Addendum No. 1

RE: Contract # C203751

Wake County (B-5121, B-5317)

Bridge #227 On US-70/US-401/NC-50 Over Peace Street And

PROJECT REFERENCE NO.	B-5121 / B-5317	SHEET NO.	UC-5
DESIGNED BY:	DGB		
DRAWN BY:	JGB		
CHECKED BY:	JRP		
APPROVED BY:	JAR		
REVISED:			
NORTH CAROLINA DEPARTMENT OF TRANSPORTATION		UTILITIES ENGINEERING SECTION	
PHONE: (919) 707-6690		FAX: (919) 250-4151	
		UTILITY CONSTRUCTION PLANS ONLY

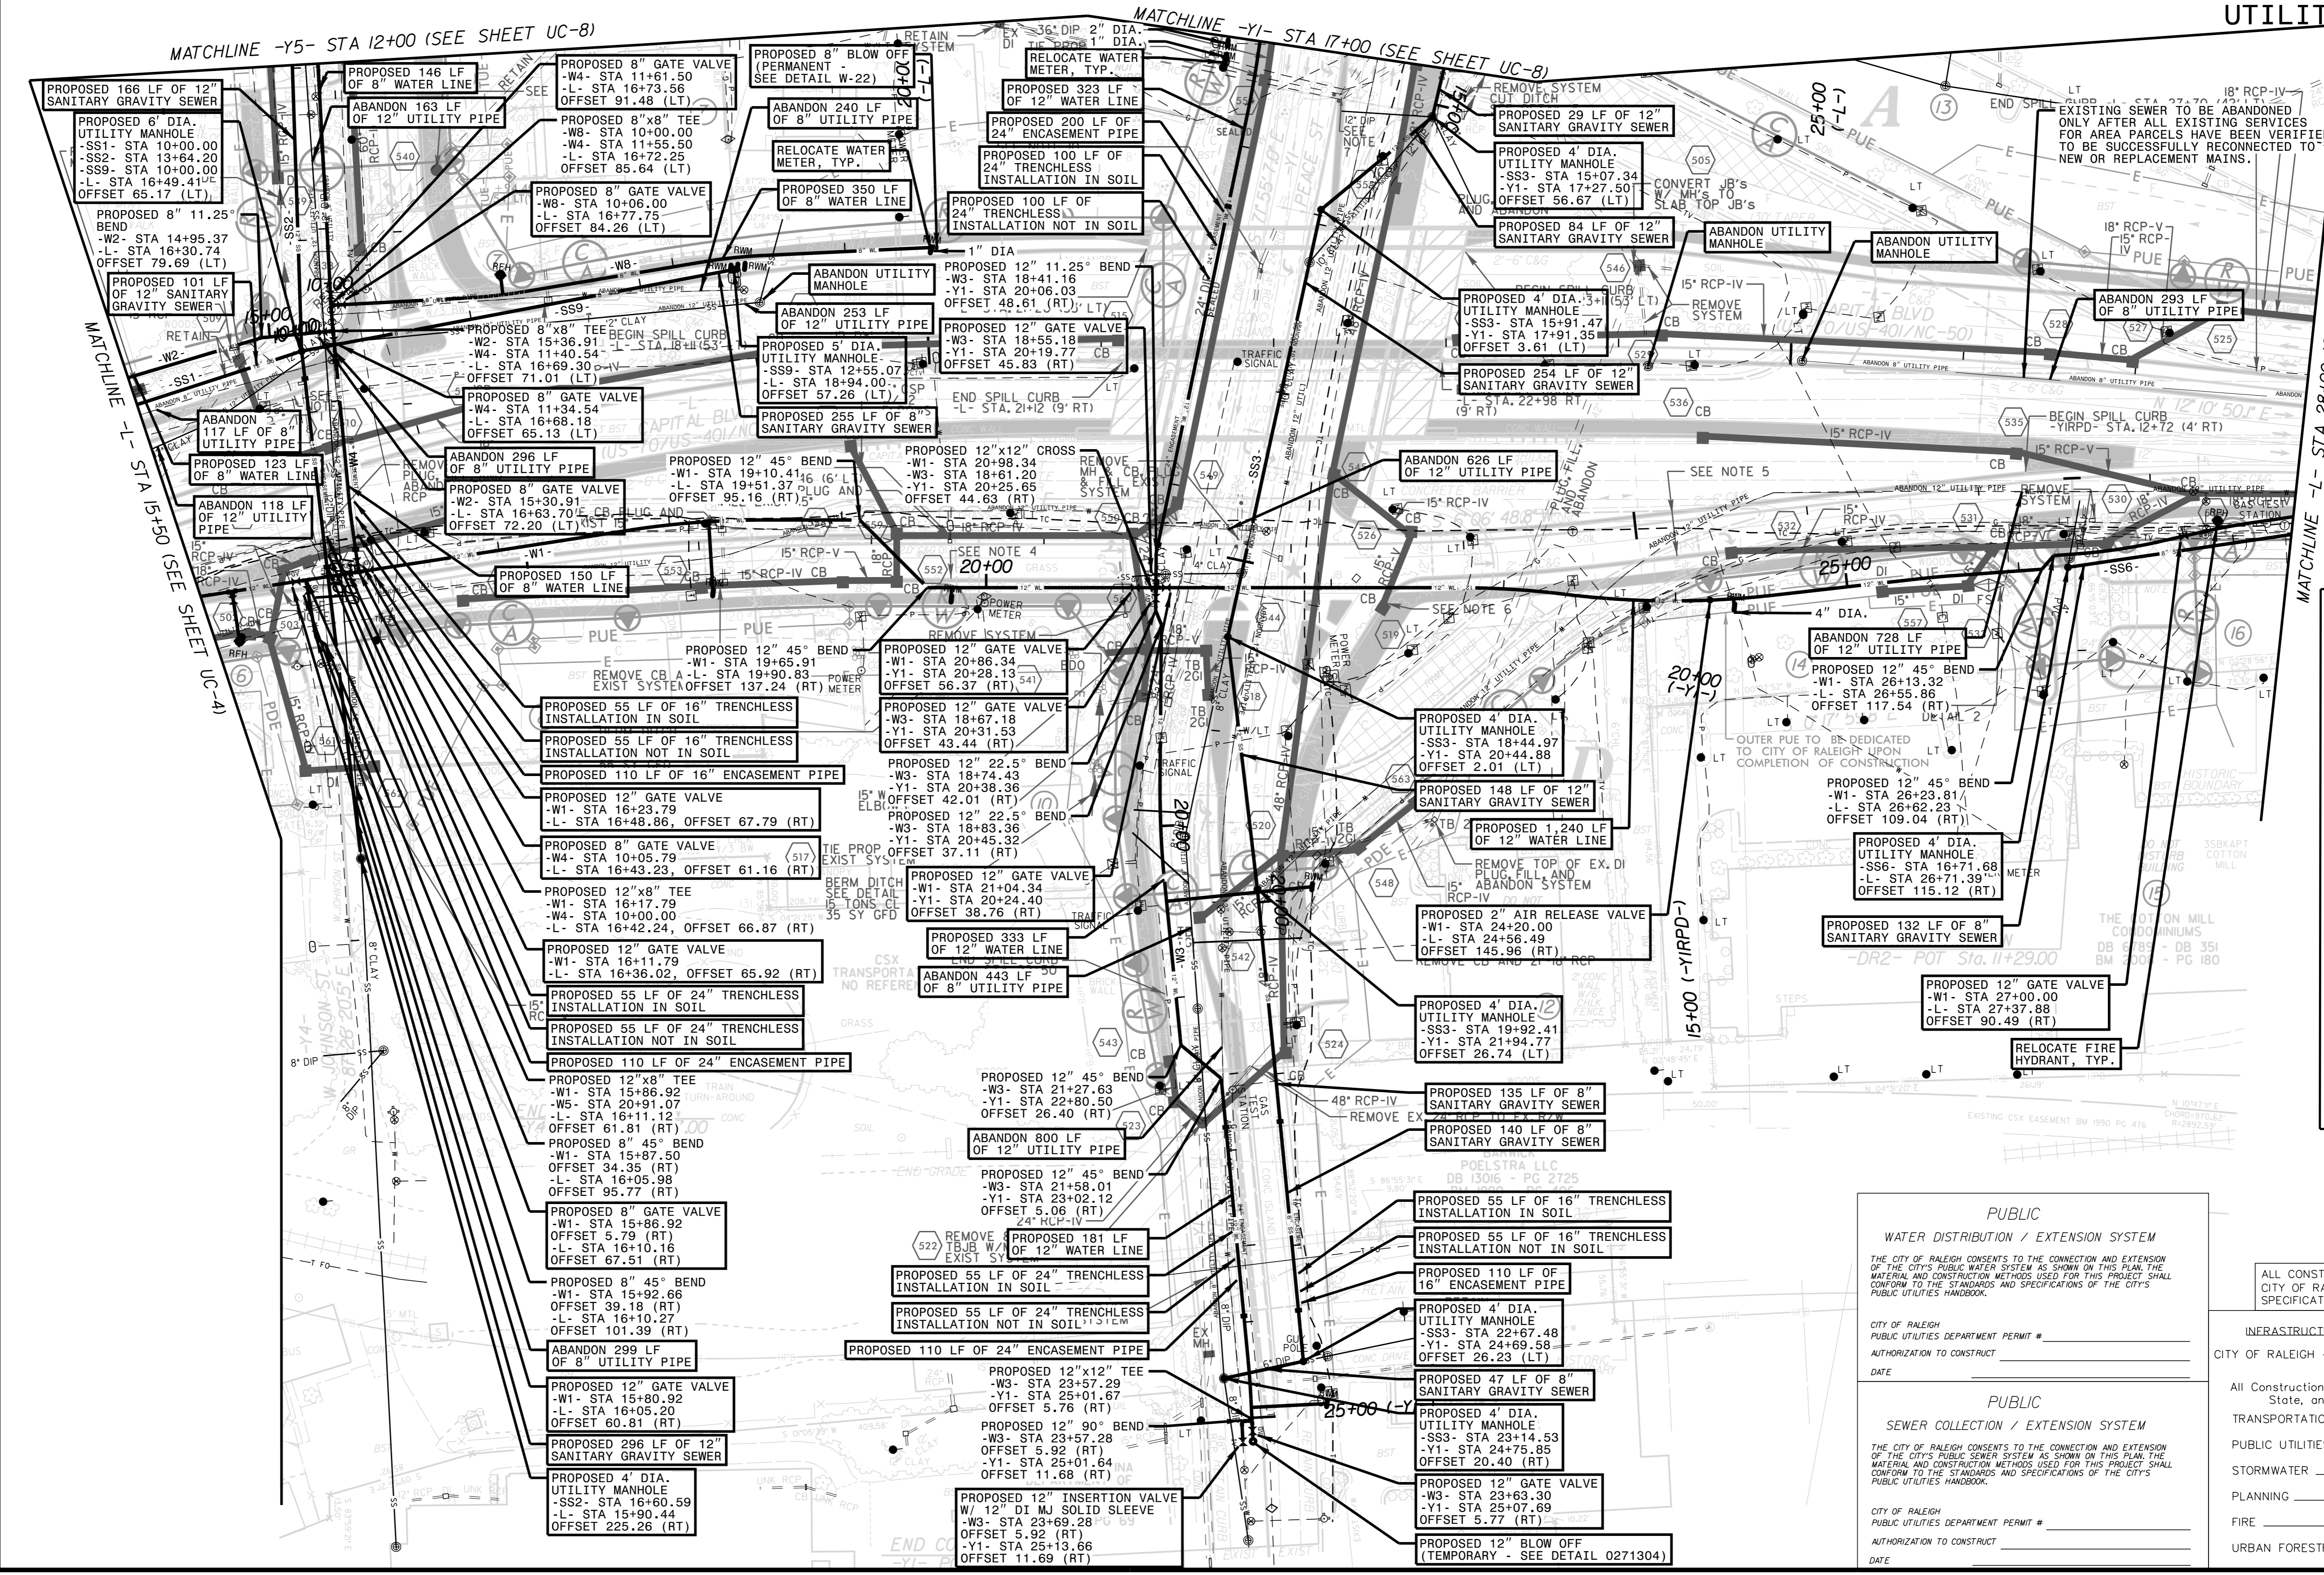
UC-01 and UC-03 thru UC-16	Suspect contaminated area limit level shown on all sheets; Trenchless installations on Capital Blvd. below railroad bridge revised to open cut installations,; Replacement of -SS5- has been removed from the plans, and a manhole added to -SS6- as a result thereof; limits of disturbance shown on City of Raleigh property, where easement is not required; water meter sizes specified on plans, if not standard 5/8" diameter services; UbO design removed from all sheets; Limits of contaminated groundwater pipe protection measures shown on profiles
UO-2	Proposed light poles and conduit added; changed note 6 to update lighting information
UO-3	Proposed light poles and conduit added; changed note 6 to update lighting information
UO-4	Proposed light poles and conduit added. Proposed gas revised to retain existing gas line and spot adjust depths for drainage; changed note 6 to

STATE OF NORTH CAROLINA DEPARTMENT OF TRANSPORTATION RALEIGH					
DOUBLE 11 FT. X 7 FT. CONCRETE BOX CULVERT BARREL SECTIONS					
REVISIONS					
NO.	BY:	DATE:	NO.	BY:	DATE:
1			3		
2			4		
SHEET NO.					C-4
TOTAL SHEETS					10

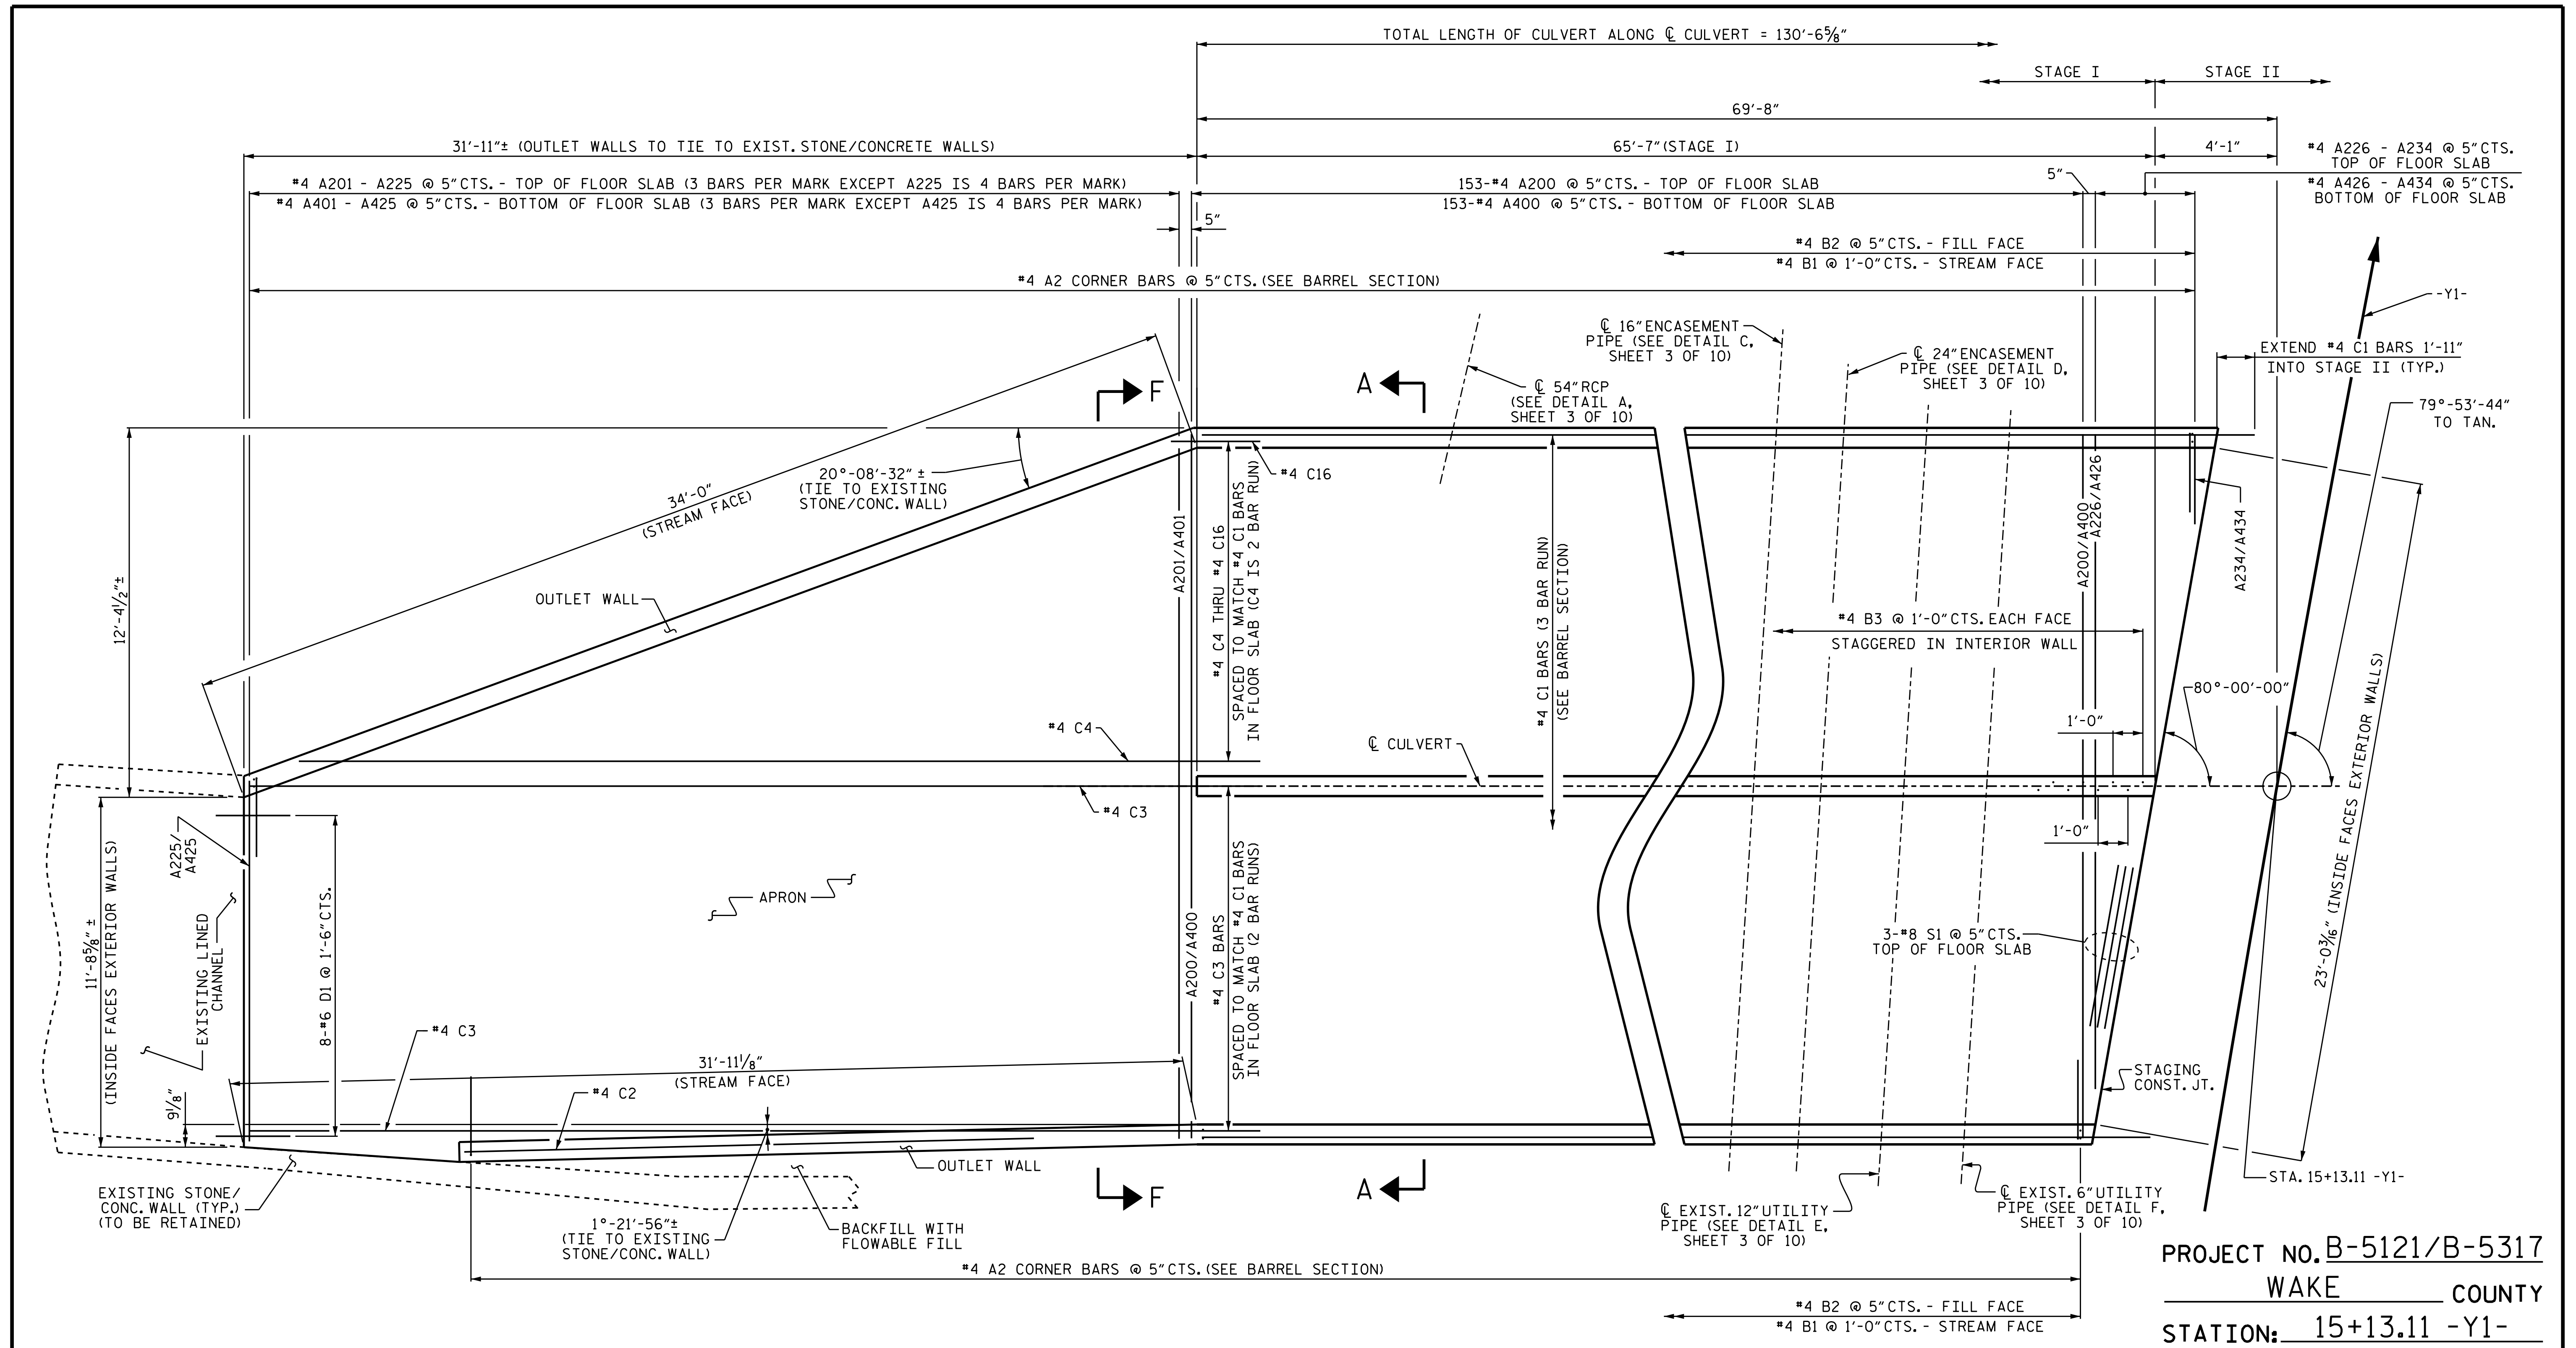
Sheet No.	Revisions
Title Sheet	Revised to change the Letting Date to July 19, 2016
S-2,S-3, S-10, S-14, S-40, S-41, S-47, S-65, S-93, S-96, S-107	Various revisions (mostly in the form of added notes) to address the addition of the metal fascia and lighting
S-42 thru S-43C	Added details for the "Architectural Metal Fascia"
S-46	Revised the note concerning removal of the existing substructure
S-109 thru S-110E	Added details for the "Architectural Metal Fascia"
C-1, C-3, C-5, C-6, C-8, C-10	Revisions to accommodate utility and drainage pipes passing through the proposed box culvert
